KITTITAS COUNTY

MEMORANDUM

TO: All Staff
FROM: Public Works Planning Review Team
DATE: May 21, 2021
SUBJECT: LPF-20-00005 Forest Ridge Final Plat Resubmittal

DWN BY	DATE	JOB NO.
T.S.	05/2021	18069
CHKD BY	SCALE	SHEET
M.K.K./D.L.P.	1" = 500'	3 OF 7

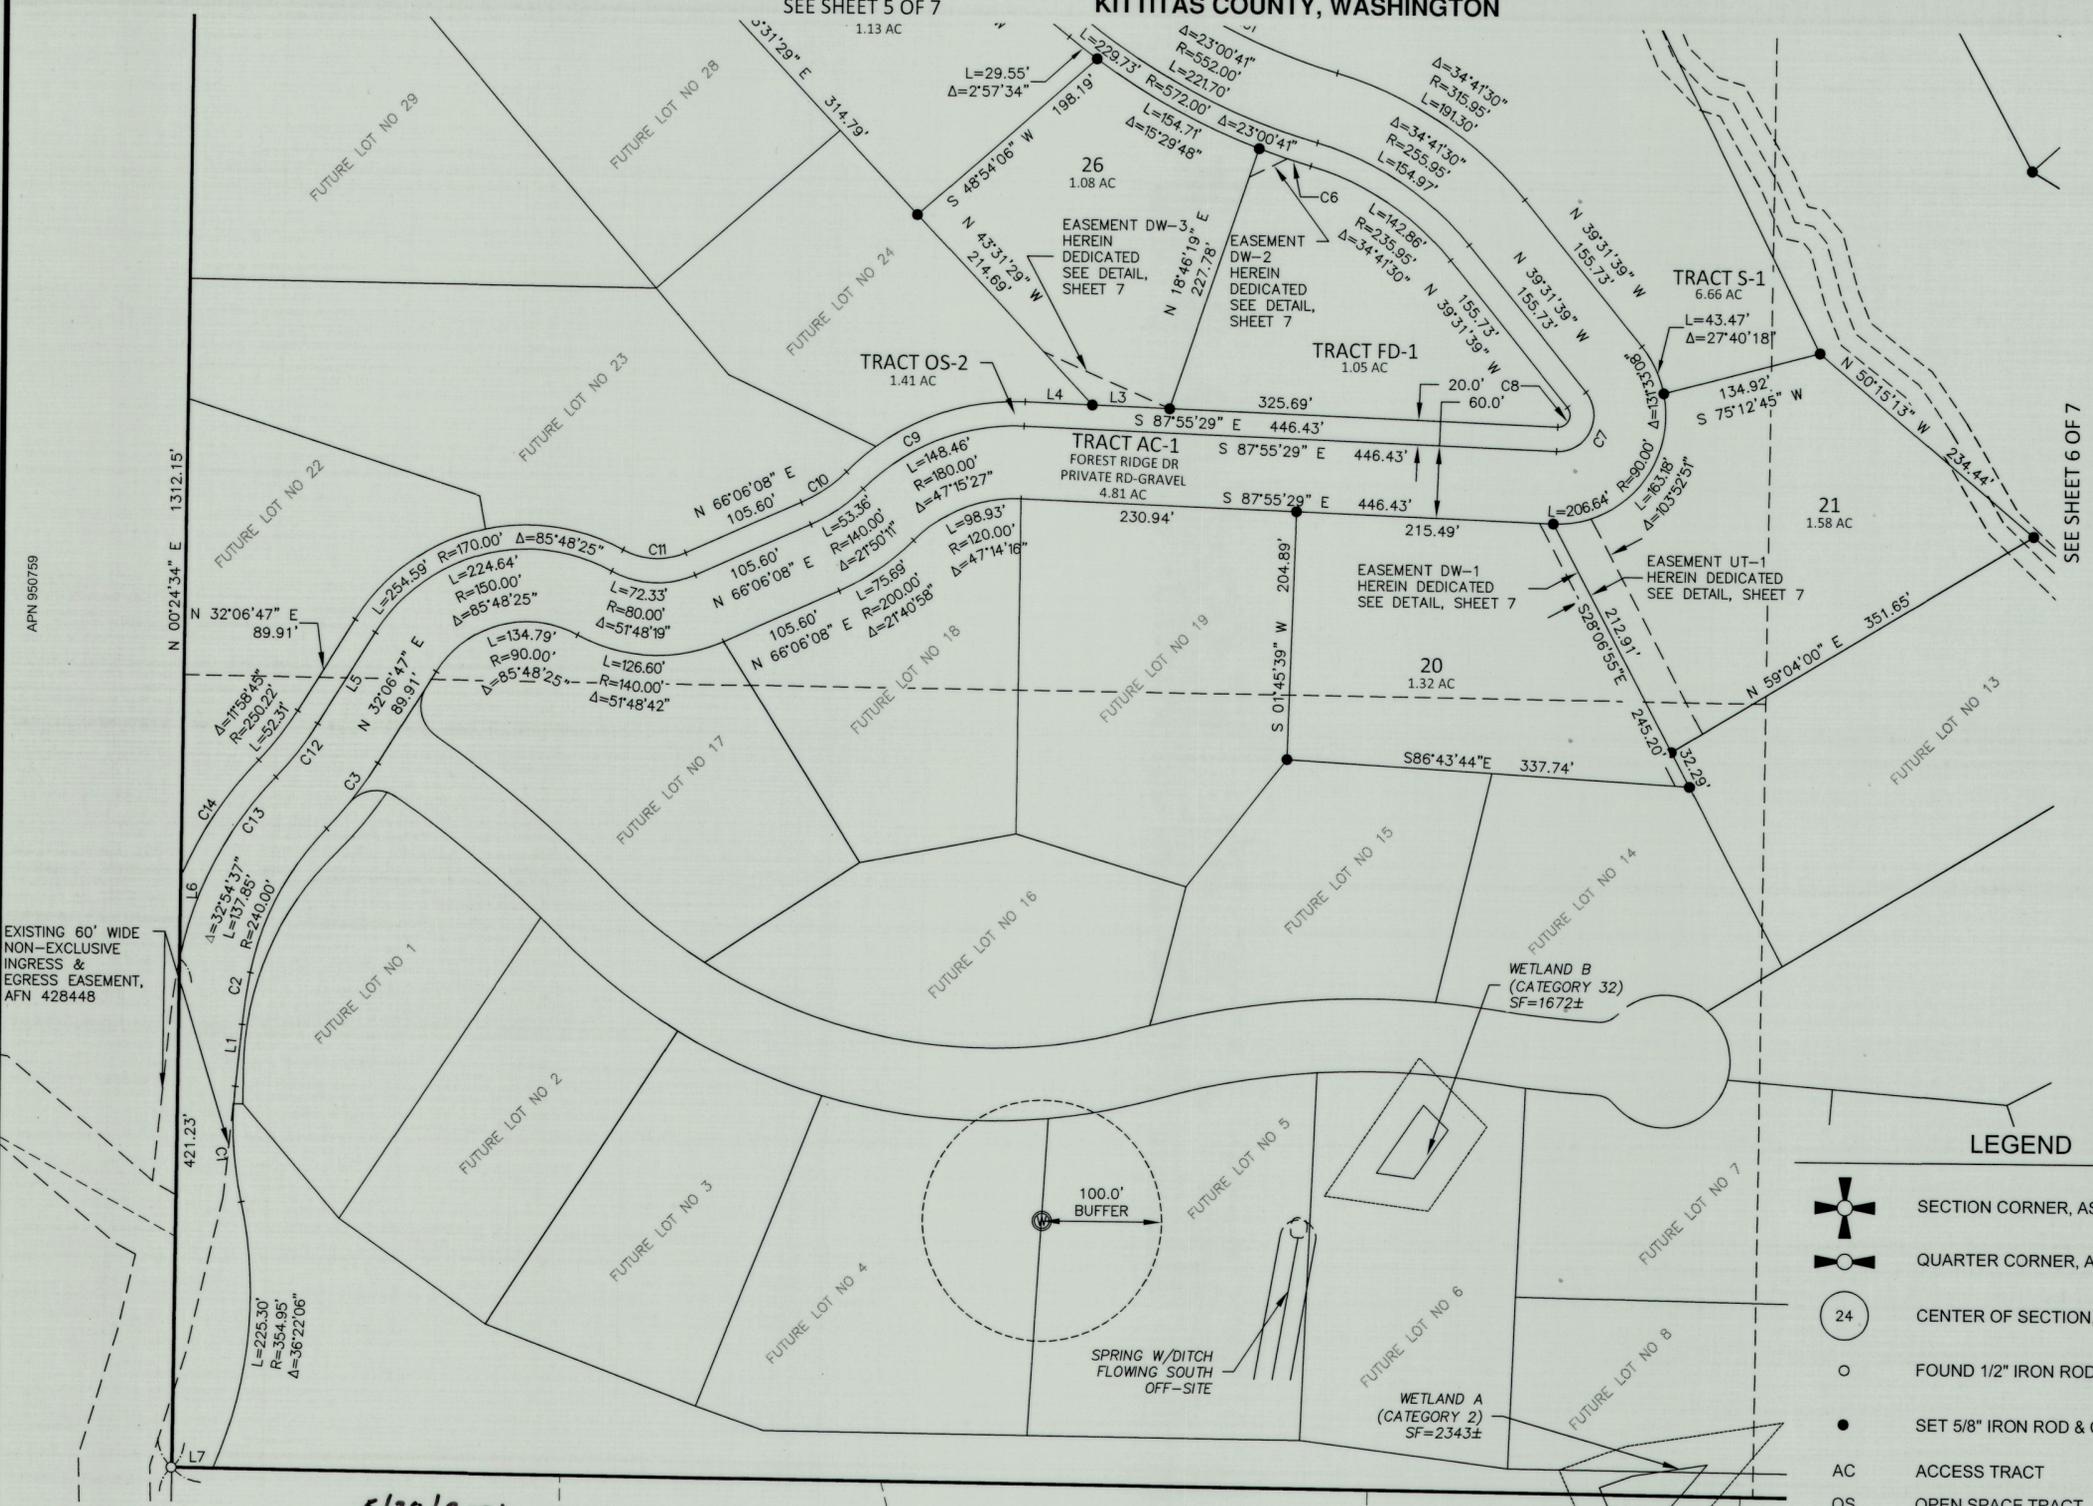
9. The N'most curve on the East line of AC-1 does not match the closure report.
10. As the Legal description identifies all the area as shown within the bold boundary on Sheet 3, the remainder area should be identified as a Lot or Tract, and area shown.

11. While it is Public Works opinion that Open Space Lots do not need to have corners staked, under the current configuration, it gives the appearance that Tract OS-1 is bounded by the outer plat boundary which WOULD need corners set. If comment #10 above is addressed, then Tract OS-1 clearly falls inside the plat boundaries and corners would not be required.

DWN BY	DATE	JOB NO.
T.S.	05/2021	18069
CHKD BY	SCALE	SHEET
M.K.K./D.L.P.	1" = 100'	4 OF 7

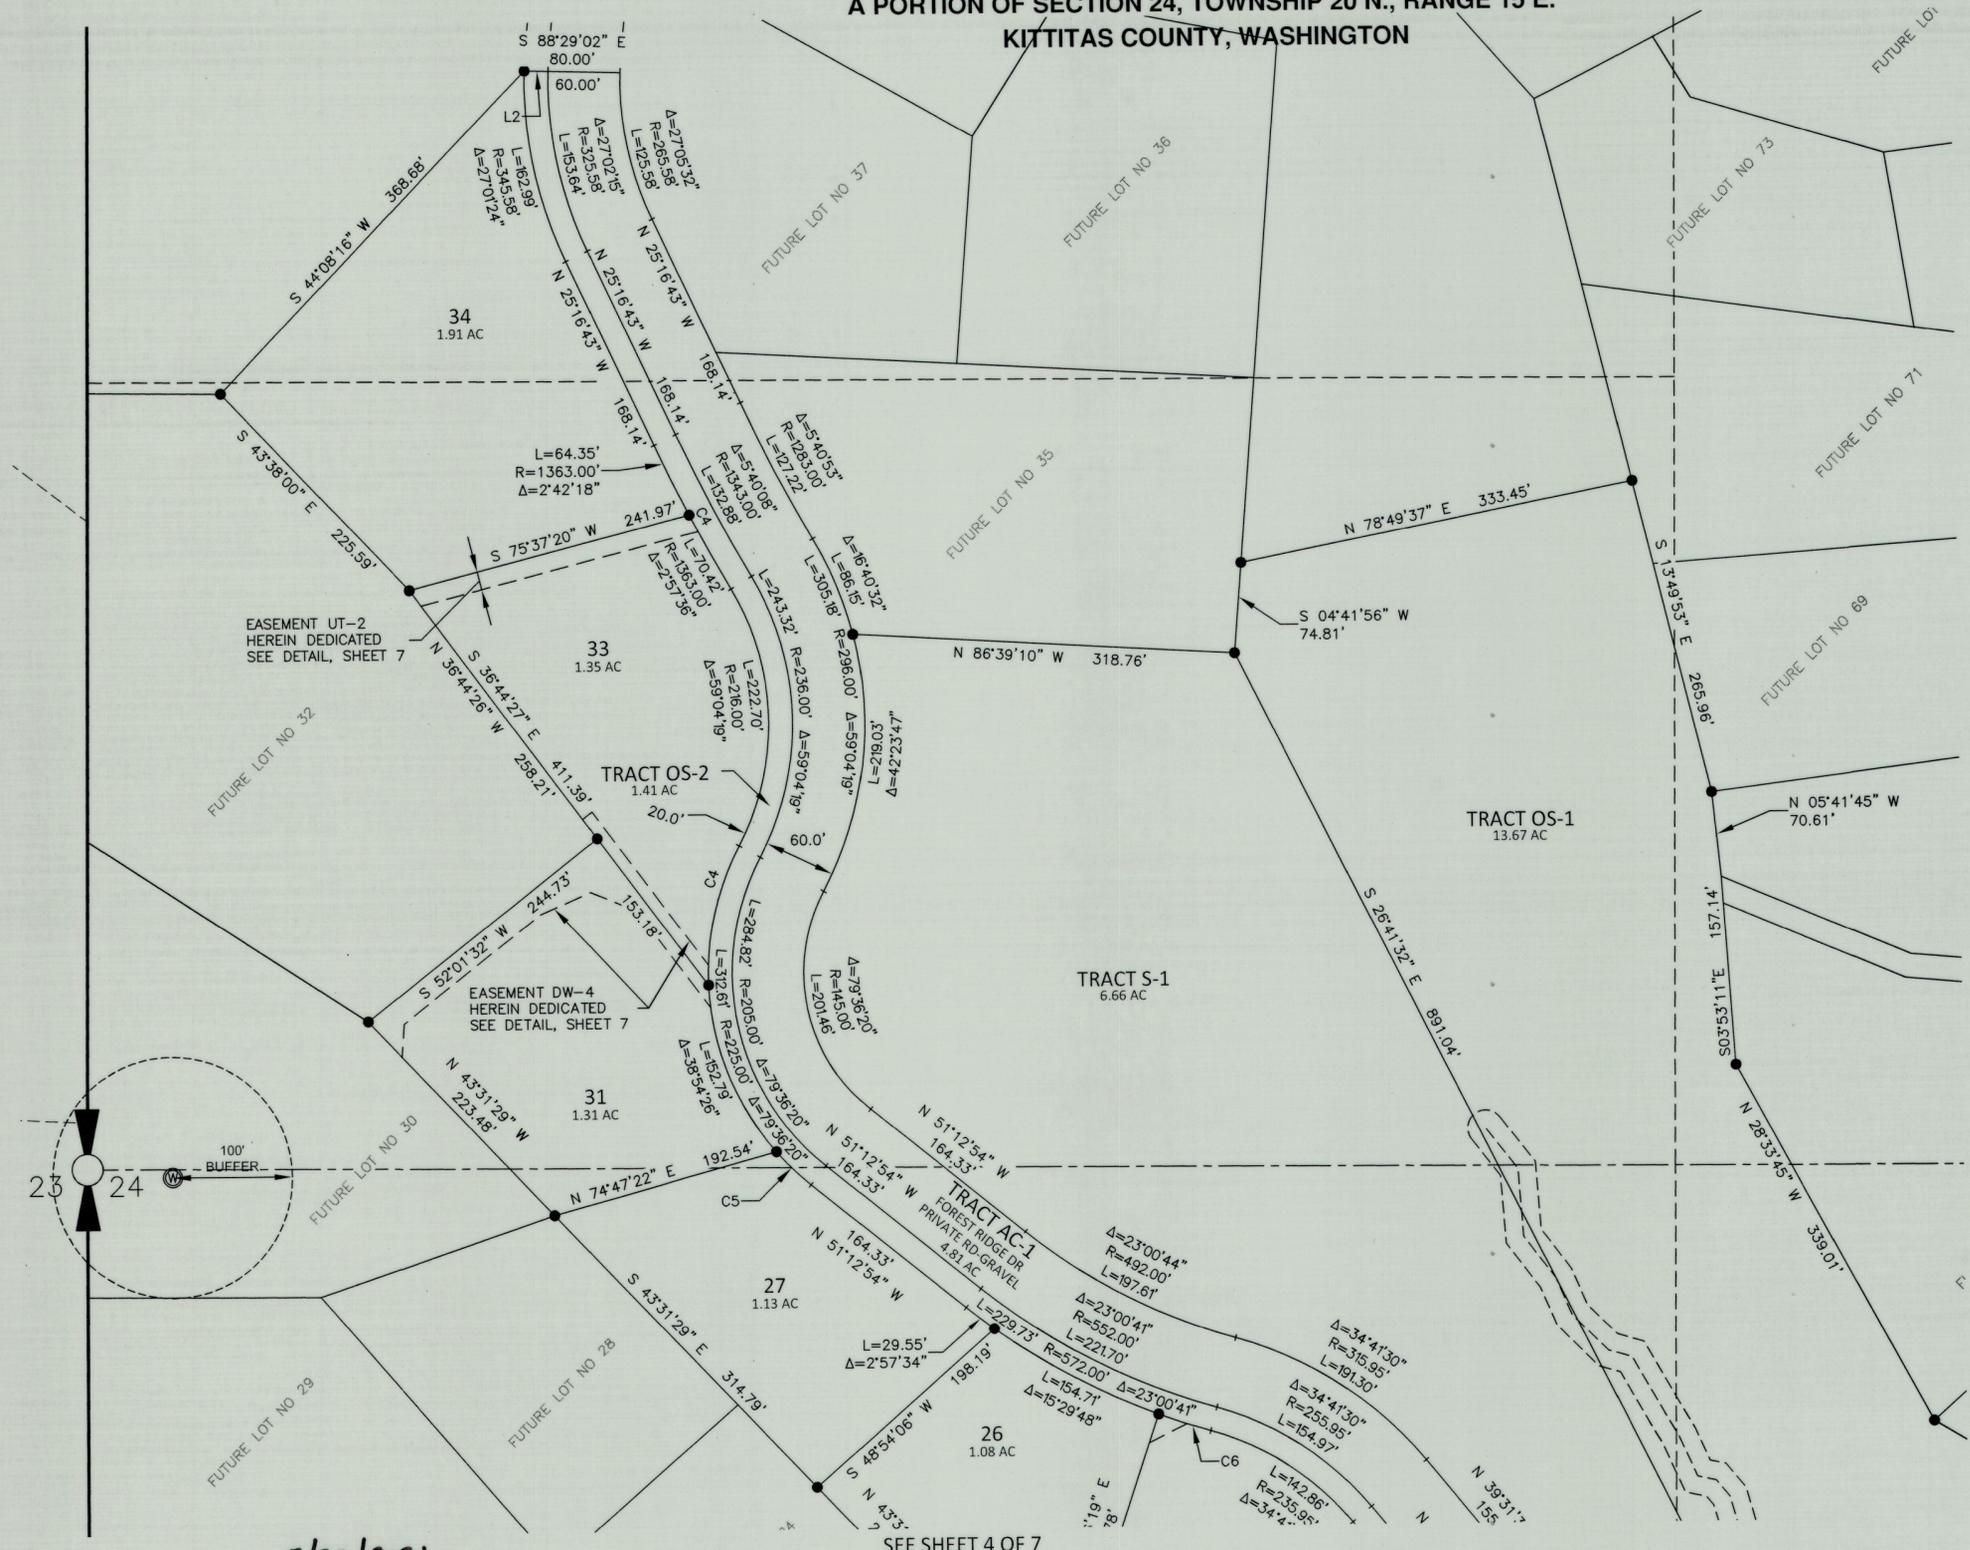
7. Sheet 4 and 5 of 7 references Easement detail sheet 6, for example reference on Tract FD-1. Reference should be to detail sheet 7.
8. Tract AC-1 is identified as Forest Ridge Drive, a private gravel road. KCC 12.12.010 requires a Private Road Maintenance Agreement. If this will be under a home owners association, please include the following note on the face of the plat: *Private Road Tracts, Drainage Pond tracts, Service Tracts, Access Road Tracts, and Open Space tracts are hereby granted and conveyed to the homeowners association upon recording of this plat. Except as otherwise noted, hereon, said Homeowners association is hereby responsible for all maintenance and management obligations associated with said tracts. Should the homeowners association fail to properly maintain said tracts, the owners of all lots of this plat shall be equally responsible for maintenance of said tracts.*

2. All the easements DW-1 through DW-5 and UT-1 through UT-2 incorrectly reference sheet 6 rather than Sheet 7.
3. The dimension of 421.23 at the south end of AC-1 should show 'crows feet' to identify what the dimension is measuring.
4. There are still multiple occurrences of crossing linework obscuring text.
